# CITY OF ALBUQUERQUE

March 18, 2021

**Re: APD Law Enforcement Center (Exterior Improvements-ADA Ramp)**  
**400 Roma Ave. NW**  
**Traffic Circulation Layout**  
Architect's Stamp 03-15-21 (J14-D059)

TRAFFIC CIRCULATION LAYOUT

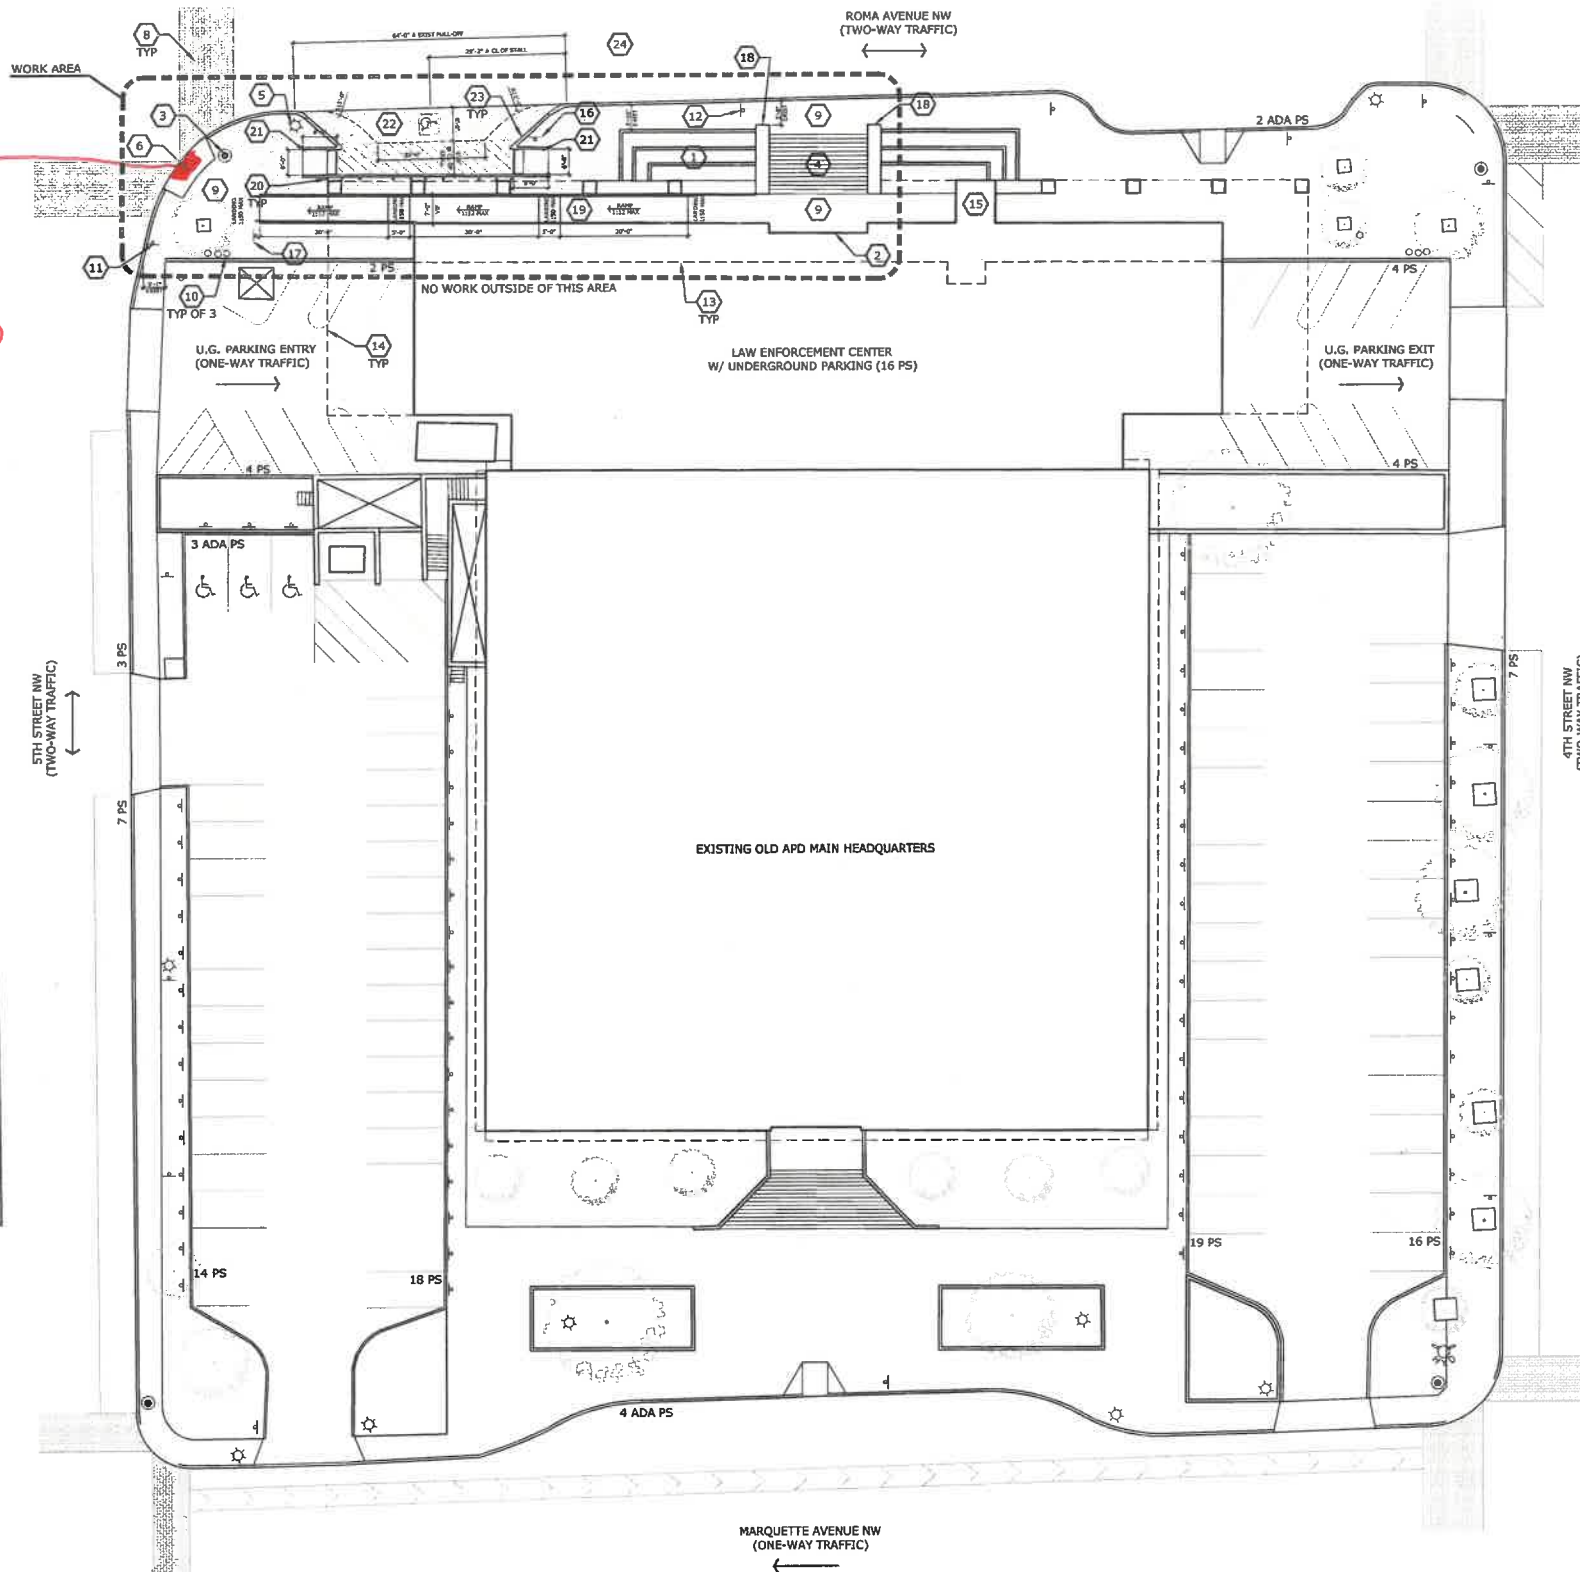
1. Public Sidewalk:
  - Provide existing widths.
  - Explain the status of public sidewalk thru out APD frontage? You need 6 ft of width.
2. Note 40: Need to call out the type of c&g being proposed? And Reference COA std dwg 2415.

3. Note 38: The detail needs to reflect 2% landing at bottom and top of ramp. The width needs to be 6 ft wide.
4. Note 39(proposed ramp): the total width of ADA van accessible ramp should be 16 ft. Car width= 8 ft, van access aisle=8 ft (**Discuss**). The radii's need to be 15 ft on approach and departure. Your referencing Civil sheet but you didn't submit this sheet for review. Please address. How did you determined the paving concrete design for the proposed stall of only 6 inches thick? Explain and/or provide justification for this design. Reference Detail D2 on this sheet for pavement section/design (what is the Rvalue for the subgrade prep?).

5. Note 36: The proposed access ramp length needs to dimensions to define 12:1 and 50:1 thru the length. Width?
6. Note 33: Proposed signage is facing the wrong direction.

7. Note 37: Paint bollards yellow.
8. Note 35: Arrow is pointing in the wrong direction.
9. Note 29 & 11: Sign facing the wrong directions.
10. Note 34: Explain the signage location?

11. Note 24 (at corner of 4<sup>th</sup>/Roma); Explain the location of stop sign on a 2-way traffic street.
12. Note 9 & 10: Is existing ADA parking stall updated and current standards? Explain?

13. 5<sup>th</sup> Street Parking Site: On site you have an existing ADA parking stall without a accessible aisle and ADA accessible pedestrian route to building entrance! Their appears to be striping indirectly adjacent to the stalls but not connecting to it. Please explain the parameters of your design requirements because this is a safety concern that will need to be addressed.
14. **(If applicable)** List the number of parking spaces required by the IDO as well as the proposed number of parking spaces including bicycle and motorcycle parking and discuss with Zoning.
15. The minimum parking stall dimensions are:

16. The ADA accessible spaces must include an access aisle. Van accessible aisles should be **8ft wide**; all others should be 5ft wide.
17. Existing ADA curb ramps must be **updated to current standards** and have **truncated domes installed**.

18. **Per the IDO, a 6 ft. wide ADA accessible pedestrian pathway is required from the public sidewalk to the building entrances. Please clearly show this pathway and provide details.**

19. **Per DPM, a 6 ft. wide ADA accessible pedestrian pathway is required from the ADA parking stall access aisles to the building entrances. Please clearly show this pathway and provide details.**

20. Please specify the City Standard Drawing Number when applicable.
21. Add a note stating "All broken or cracked sidewalk must be replaced with sidewalk and curb & gutter." A build note must be provided referring to the appropriate City Standard drawing.
